Please upload onto Ocella the email below which is a further consultation response from **Environmental Health** to discharge of condition application **LU/189/20/DOC**.

Please see the email below from Rob Clark at Persimmon Homes regarding the contaminated land reports for **LU/189/20/DOC** and **LU/192/20/DOC**.

With regard to LU/189/20/DOC the condition cannot be discharged. Having reviewed Idom Merebrook's Site Investigation report (ref.: L-18426h-2.4.2-18-S445-JSS, dated 16 August 2018), the report does not meet the criteria as specified in condition 4. For example, the report does not include any elements associated with a Phase I report, there is no investigation methodology, no consideration of off-site sources of contamination and no risk assessment. The report also states that Inani Ltd. are proposing to develop the site for residential purposes, however the screening levels selected are for 'allotment use' (which tallies with the application details). The conclusion of the report states that the ground conditions are not suitable for use therefore the site requires remedial work. Consequently, the condition cannot be recommended for discharge.

Exploratory Hole Locations

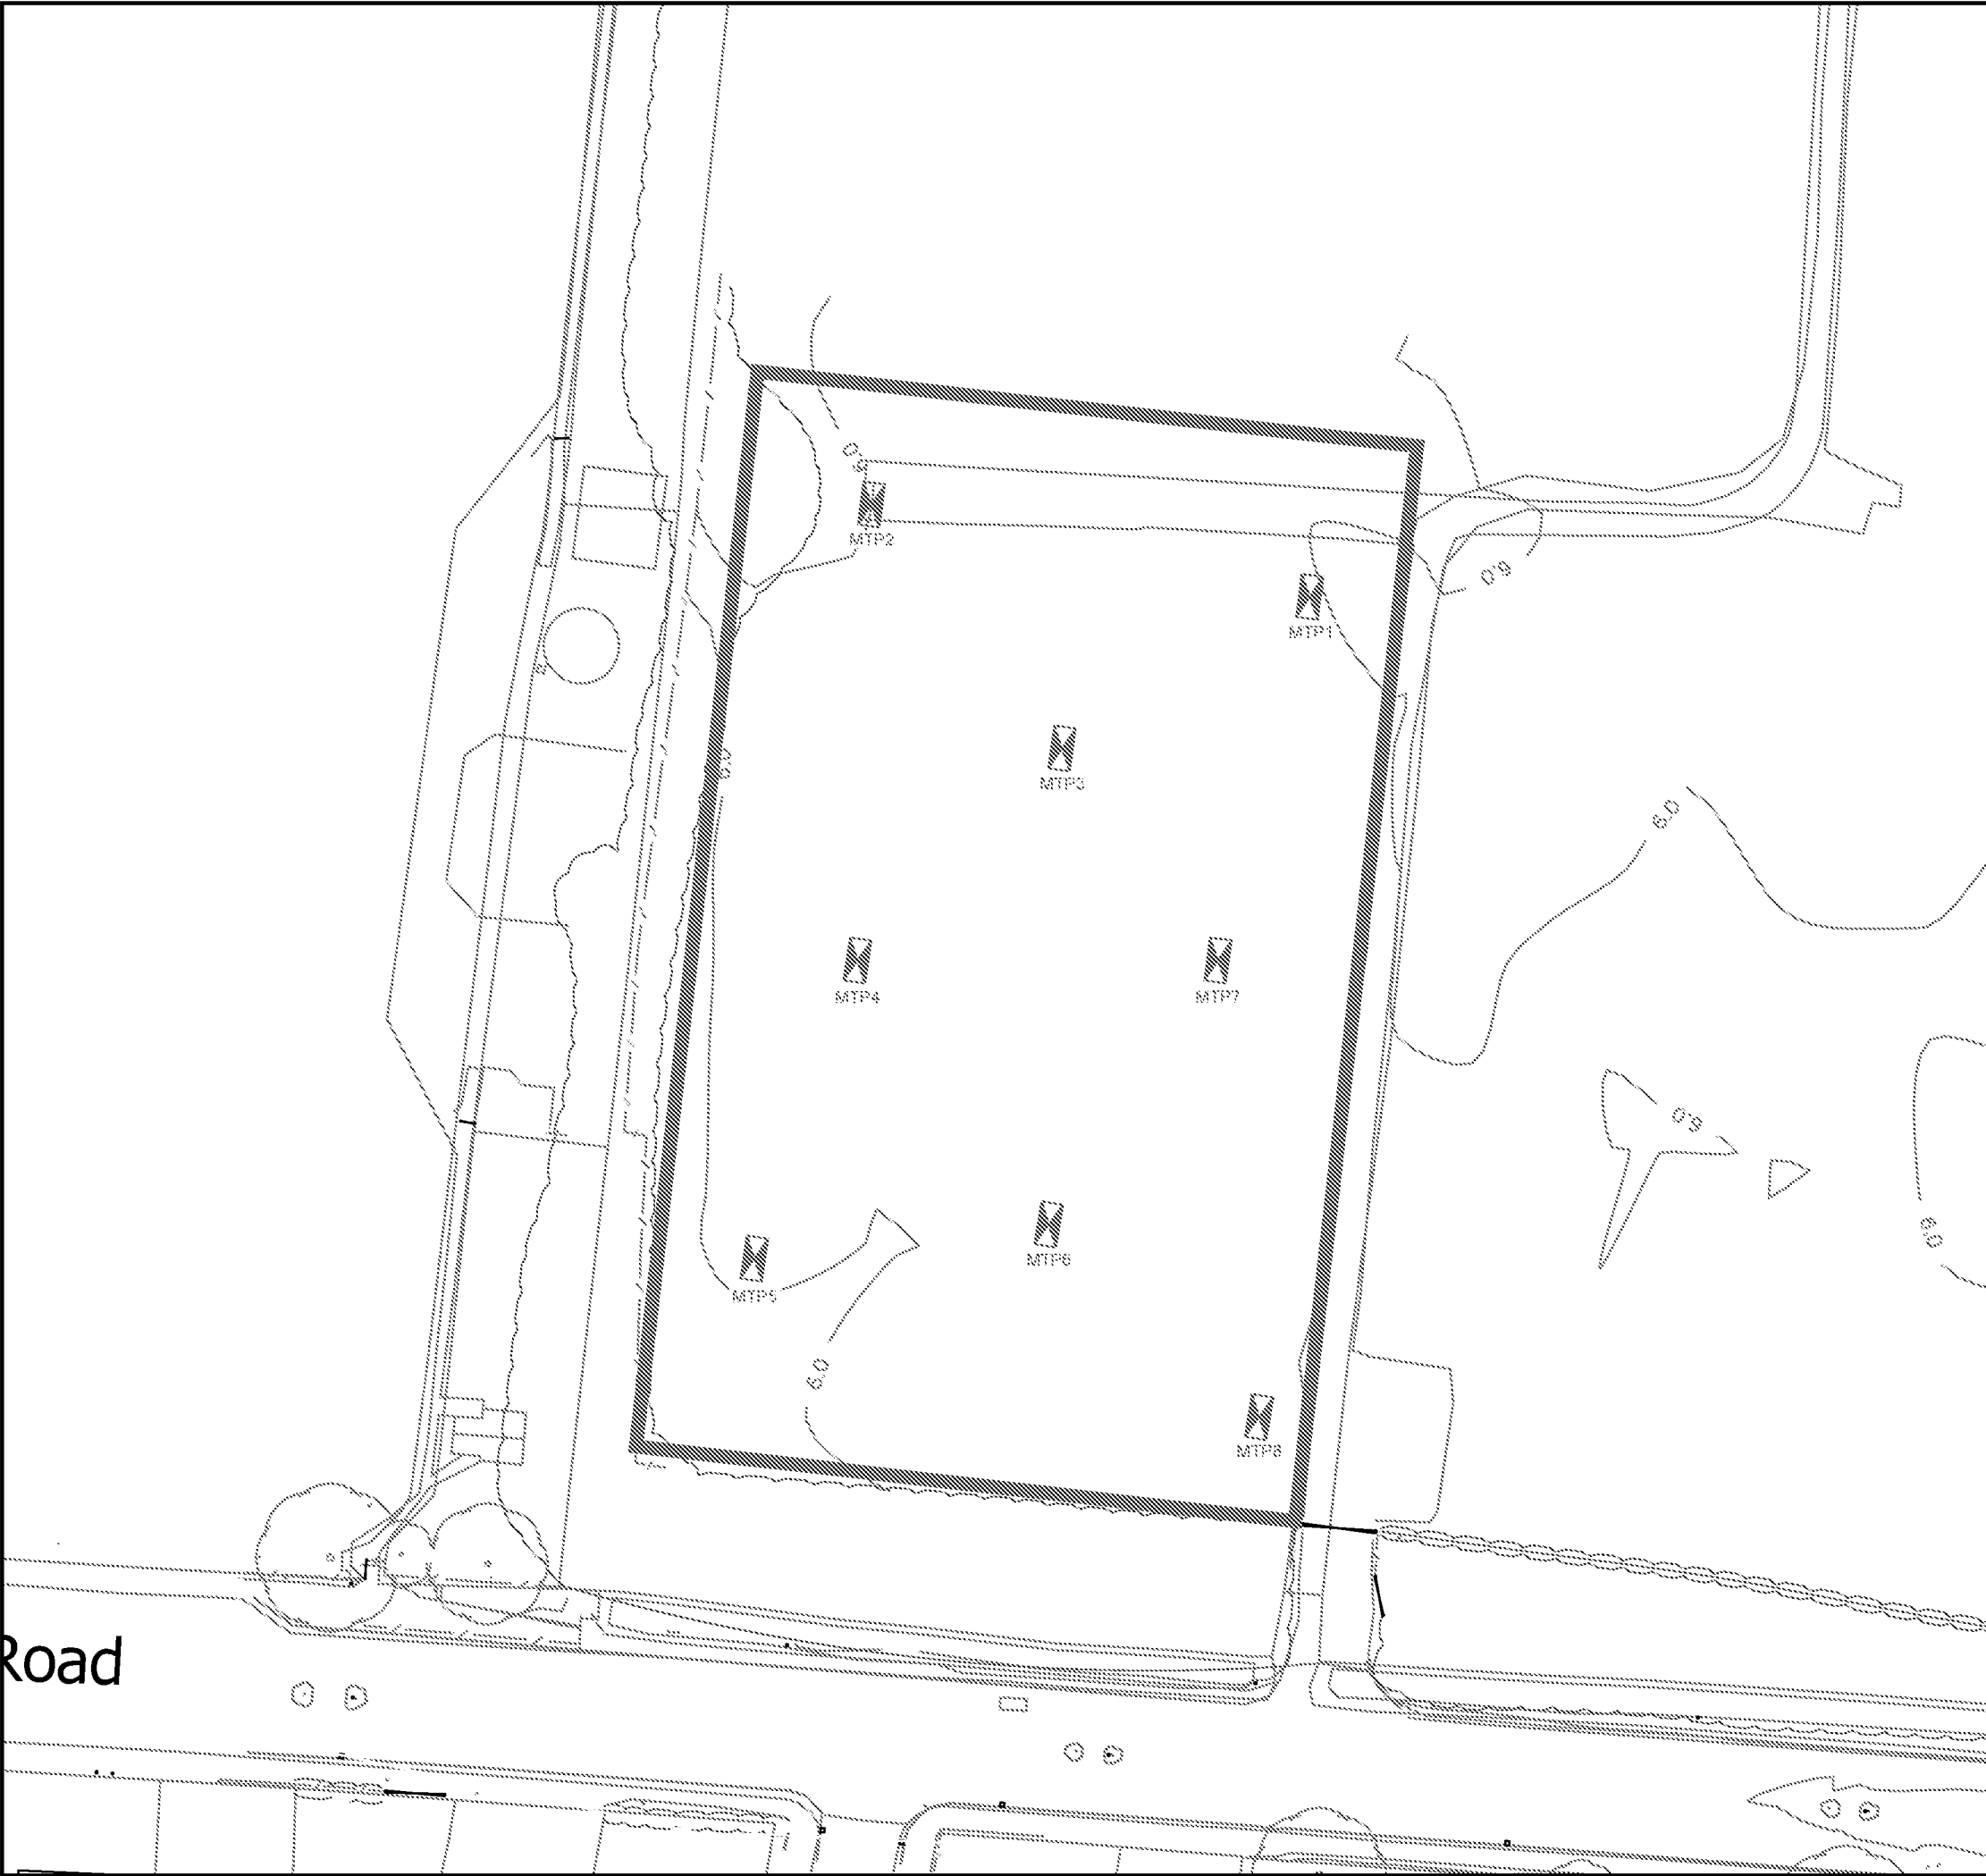
Whilst the proposed remedial method is widely acceptable, it is not necessarily applicable to all contaminated sites. The requirements of the condition are to ensure that a thorough and comprehensive examination of the subject site is undertaken and a representative picture of the site conditions is developed. This is to ensure that any potential risks to receptors are identified, quantified and where necessary, suitably addressed. As the submitted report does not demonstrate these requirements, it is not possible to recommend the condition for discharge. This aside, it is not recommended that the condition is fully discharged until all remedial and ground works are complete to account for any previously unidentified contamination.

It is recommended that existing made ground is removed to 600 mm below finished levels and replaced with clean imported soils, which comply with the screening levels for allotment use. This thickness of clean soil is considered to sever the pathways, (including accidental ingestion, inhalation and absorption) between the contaminant source (residual made ground) and receptors (future site users).

This is a standard approach for remediation of this nature and the strategy is something we need to implement ASAP otherwise we will miss the window for this year. I am not sure why additional information/ testing is required as the recommendation will still be the same: the removal of 600mm of soil and replacement with clean imported soil.
